From: Kevin O'Regan <kevin.oregan@CorkCoCo.ie>
Sent: Tuesday 27 October 2020 11:17
To: Niamh Thornton
Subject: Ummerra - Substitute Consent
Attachments: Substitute Consent DM opinion to ABP.pdf

a: Application for Substitute Consent for Further Development Ref. No. ABP-308194-20
Section 37(L)(12)(a) of the Planning and Development Acts 2000 as amended:

Opinion of the Divisional Manger (South), Cork County Council in accordance with Section 37L(12)(a), having particular regard to Section 34(2) to consider the proper planning and sustainable development of the area.

MONITORING POINTS LOCATION PLAN

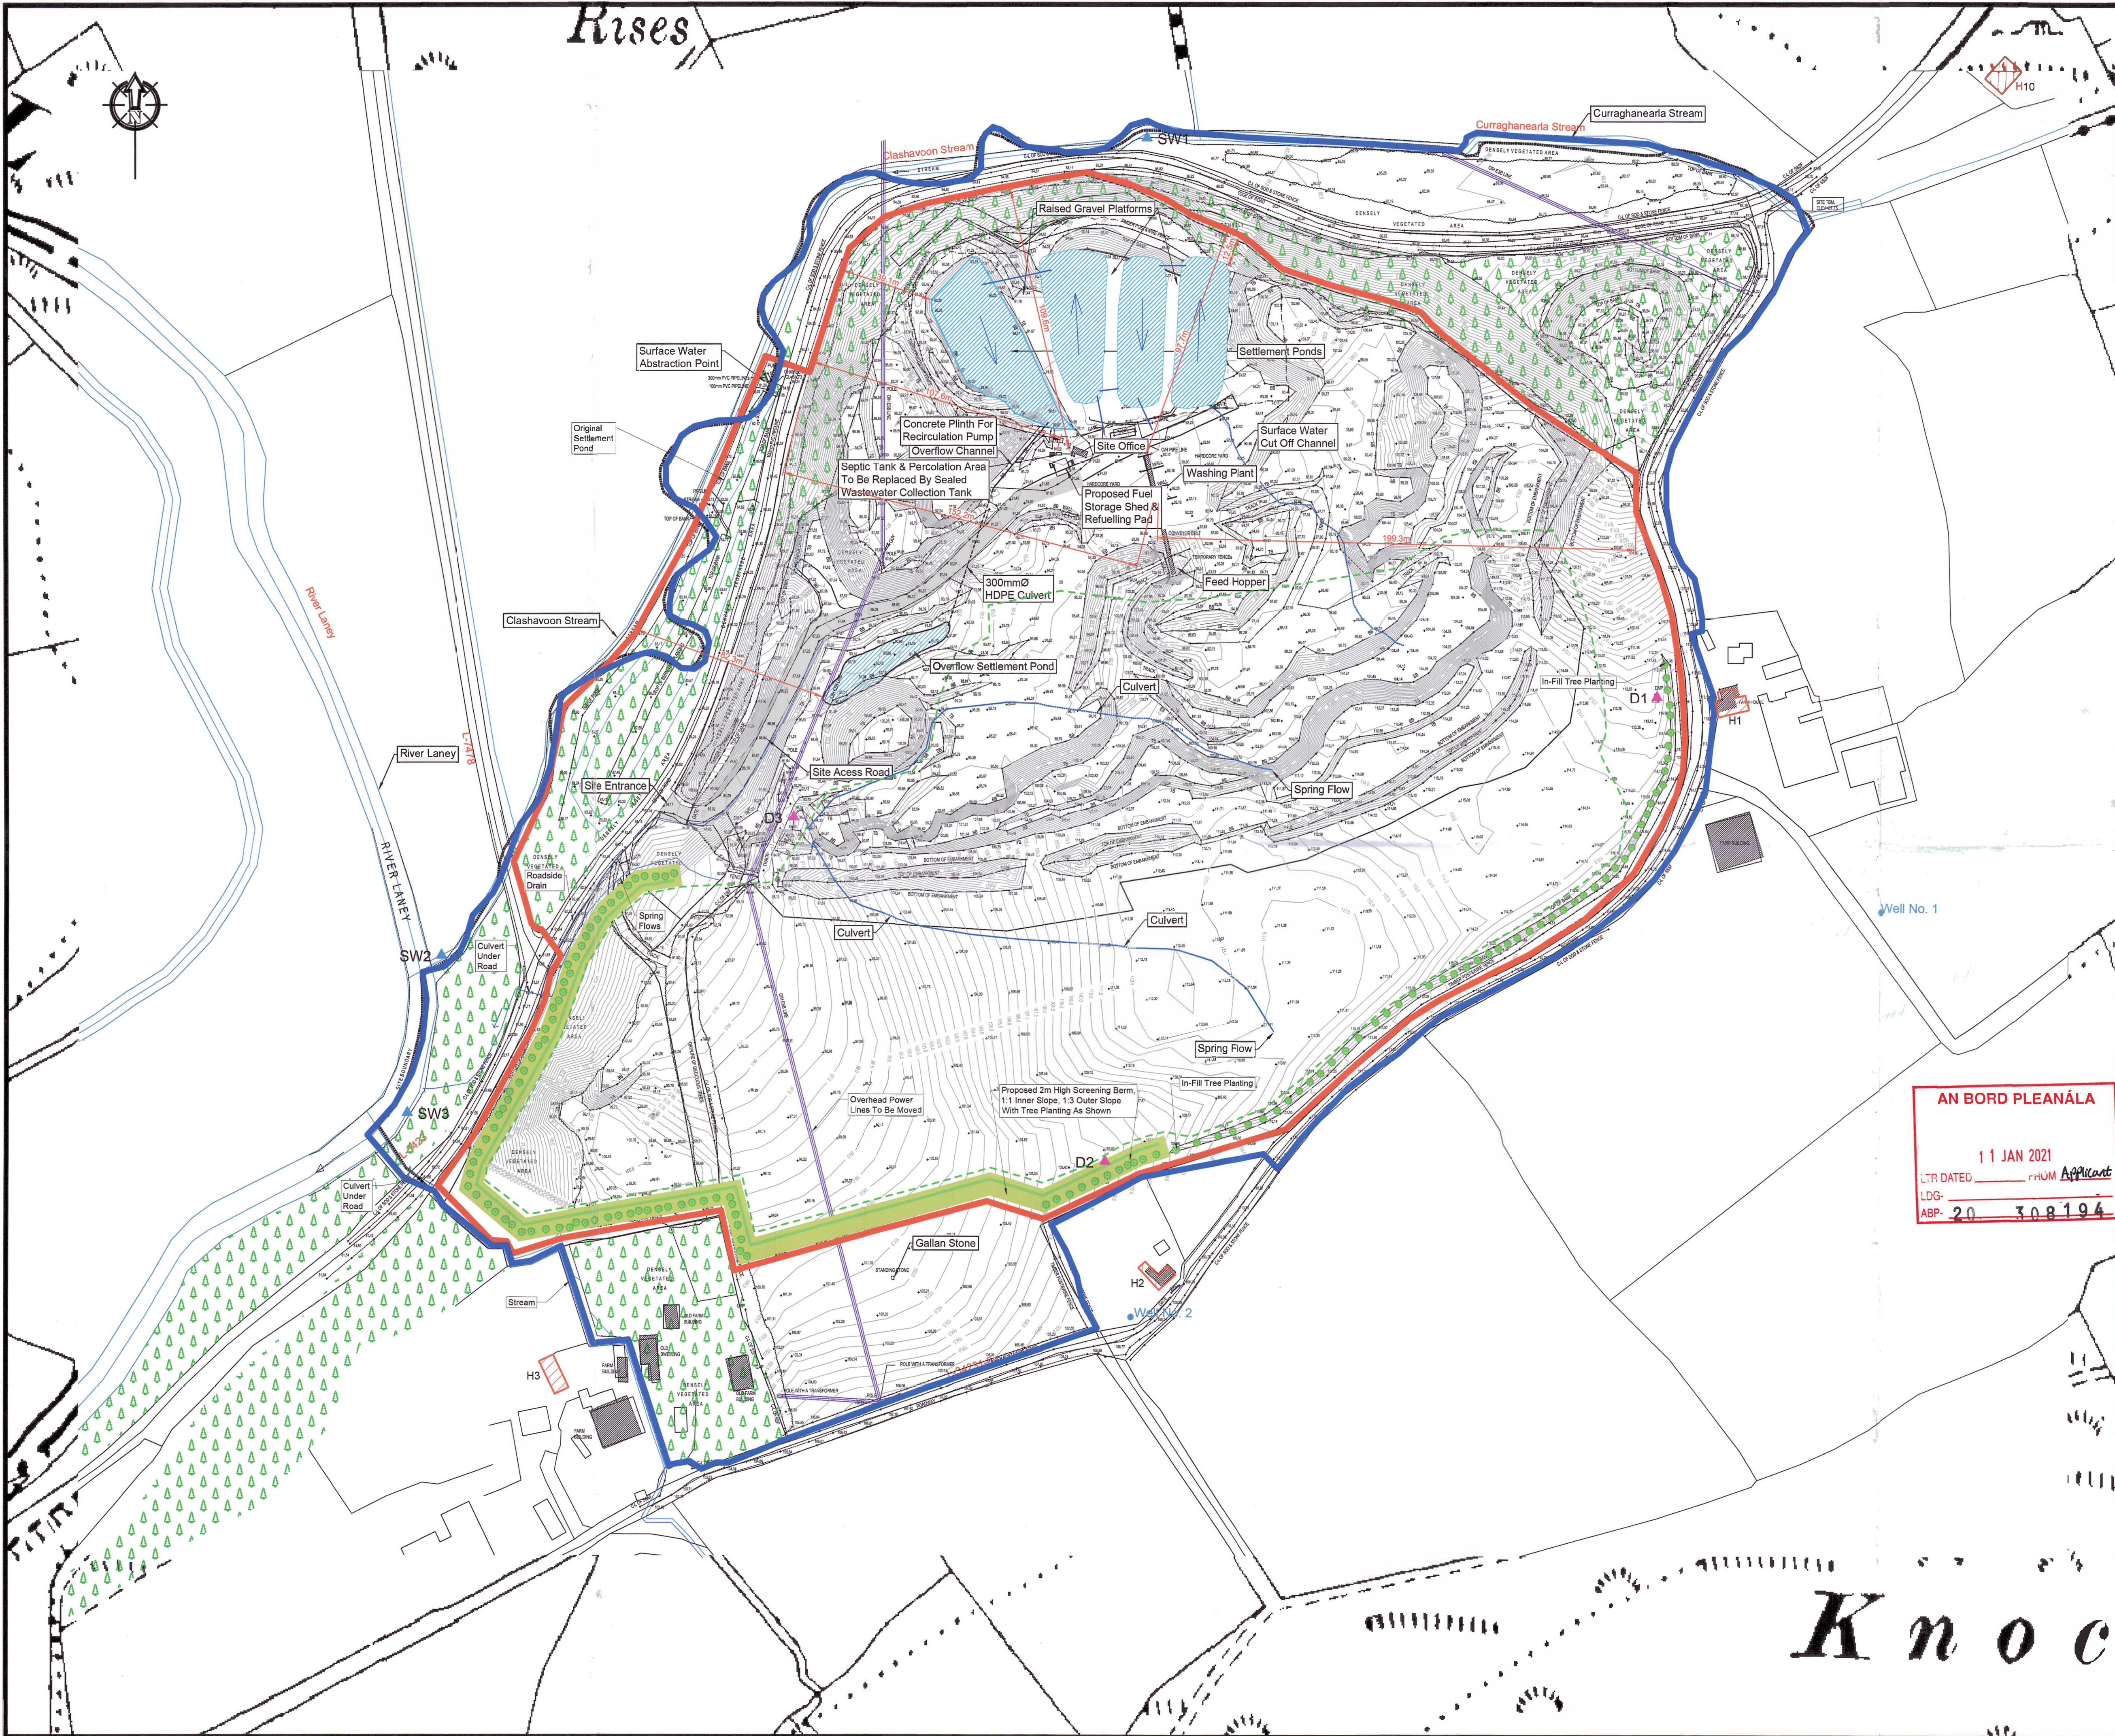
1. A suitably scaled map should be submitted showing the location of all dust sensitive receptors relative to the proposed further development boundary. The locations where all dust monitoring have been conducted relative to same should also be included.
2. A comprehensive dust monitoring and management plan should be put in place to assess and evaluate existing dust levels. This, along with accompanying meteorological data, should be undertaken to enable the assimilative capacity of the receiving environment to be determined.
3. Clarify how the 15kmh speed limit is enforced at the site. This is noted and submitted as an existing dust suppression measure employed at the site.
4. Submit proposals for the on-site sprinkler system, which should be a part of the dust mitigation strategy.

Title
HABITAT MAP

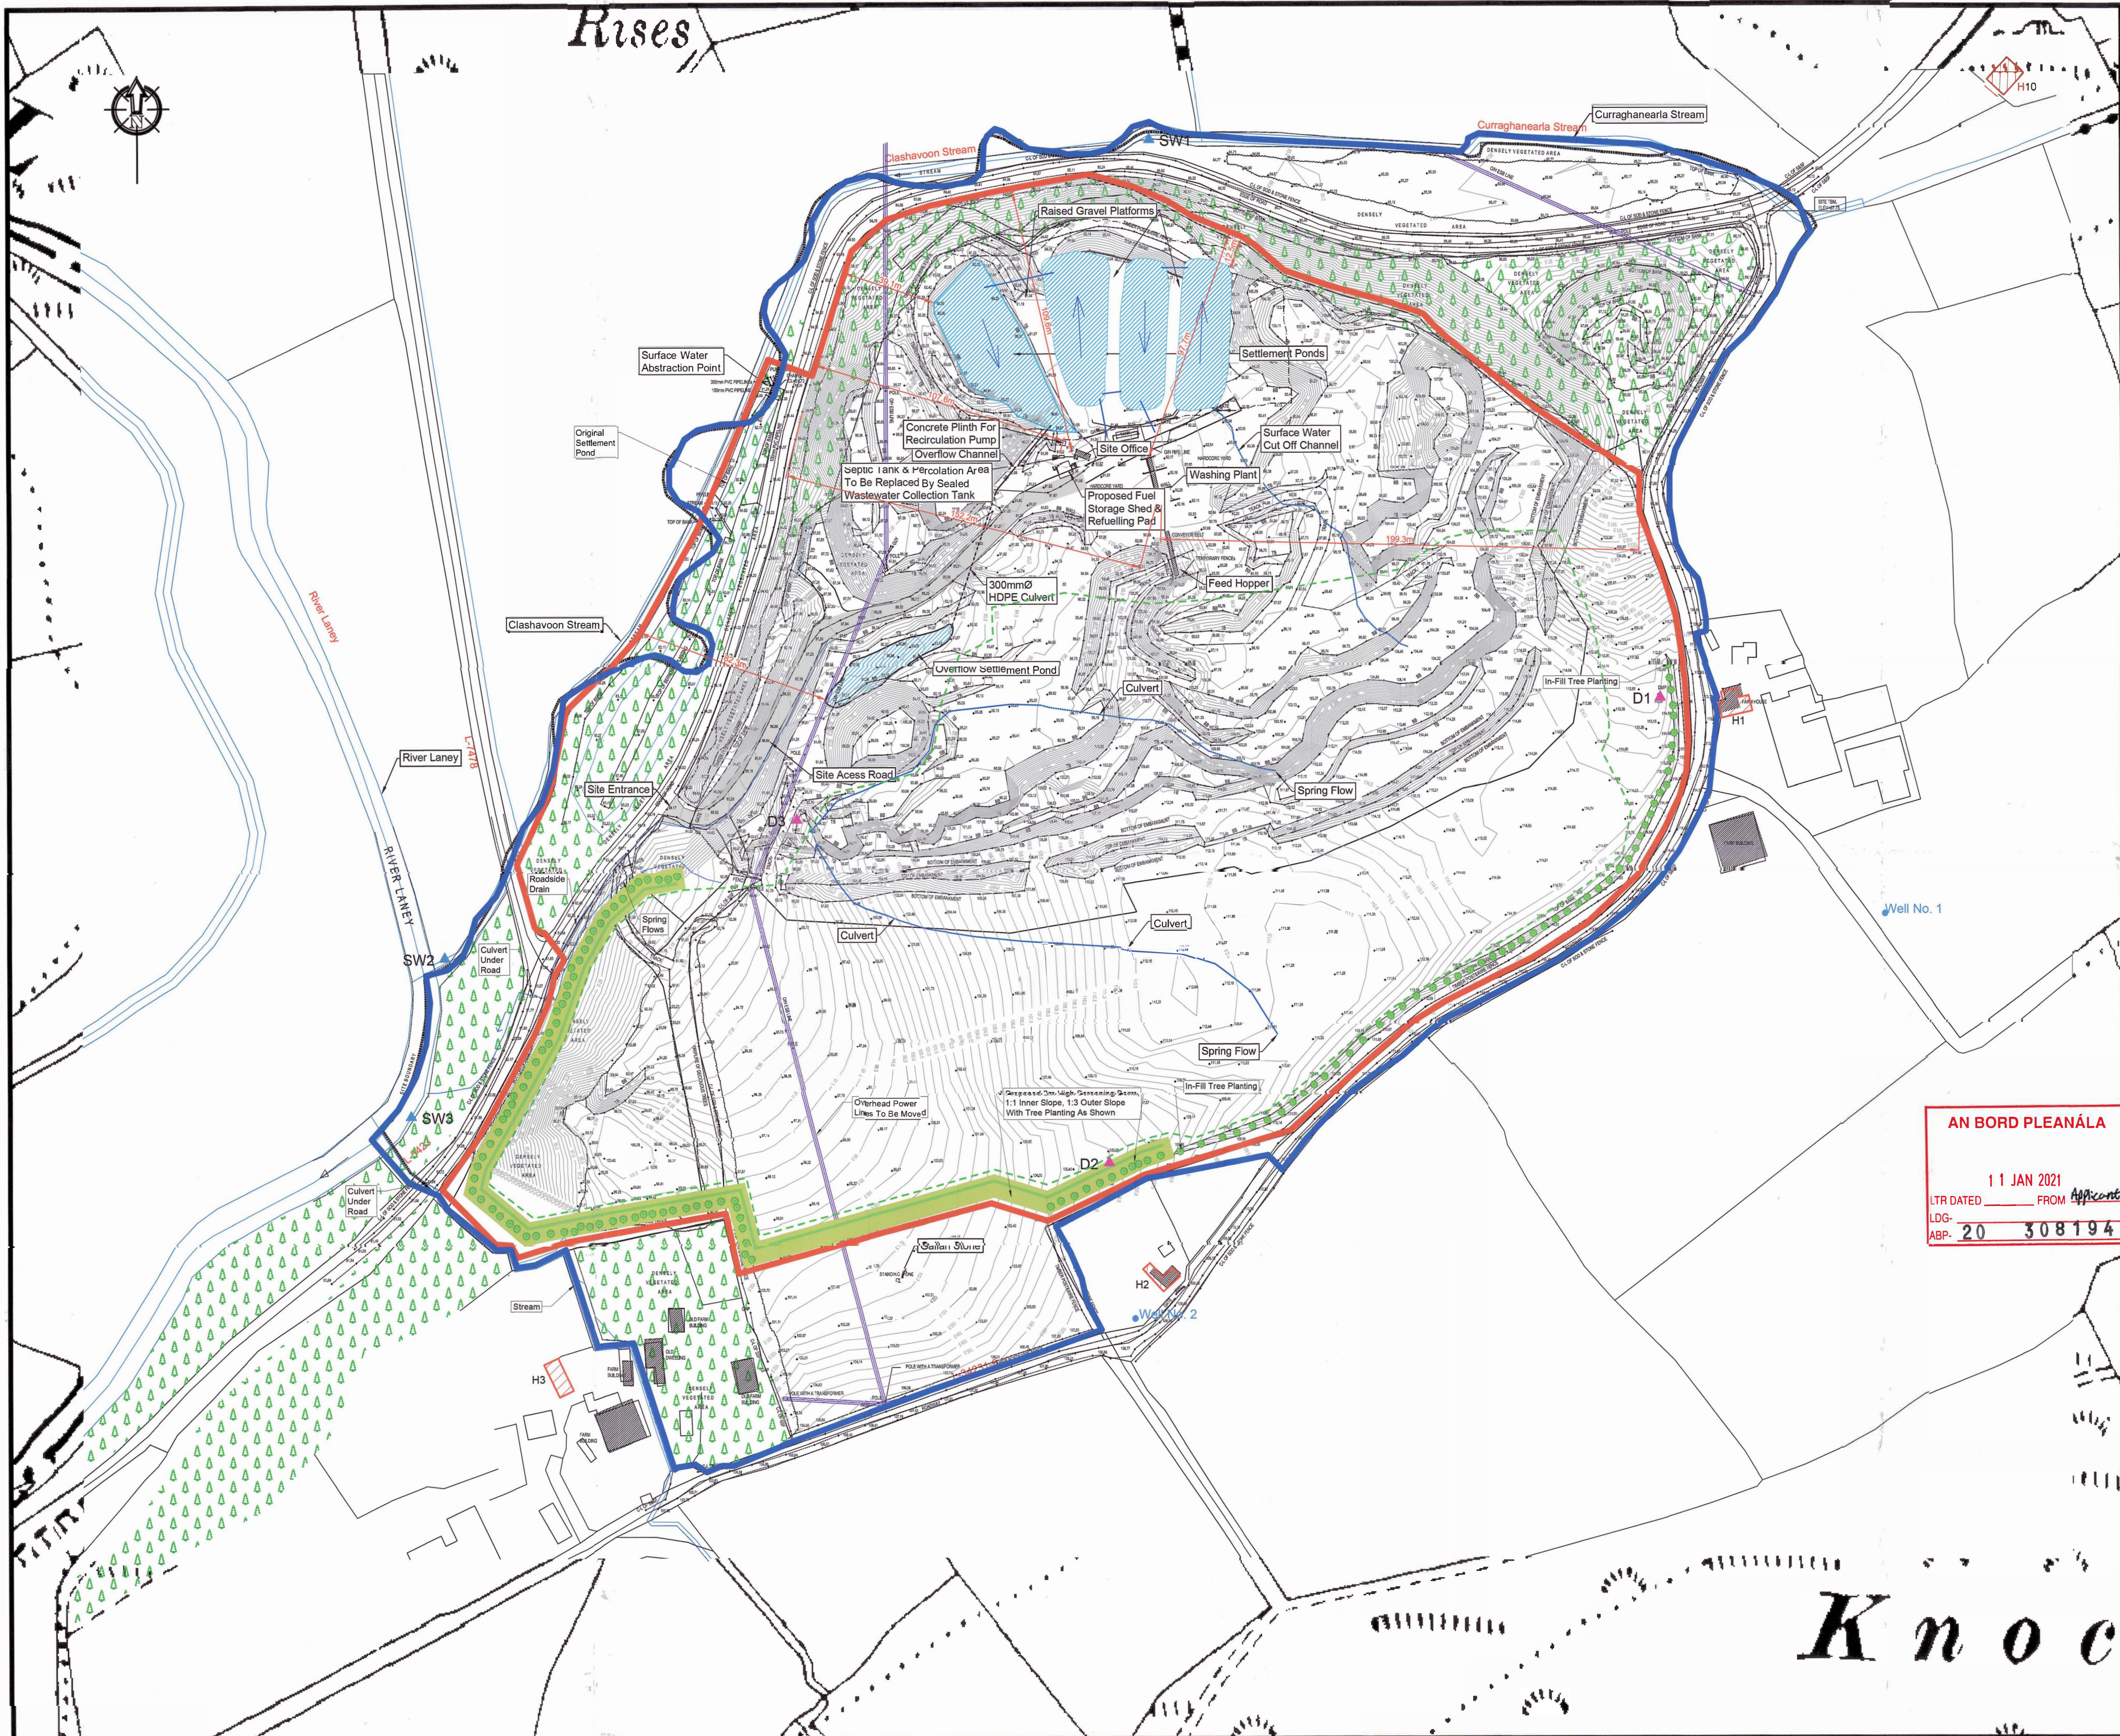
8. An outline Habitats and Species management Plan prepared with input from an Ecologist to include:
 - A map identifying proposed future works areas overlain on a habitat map and clarification as to the extent and type of habitats which are proposed to be removed during the future operational phase and habitats which are proposed to be retained;
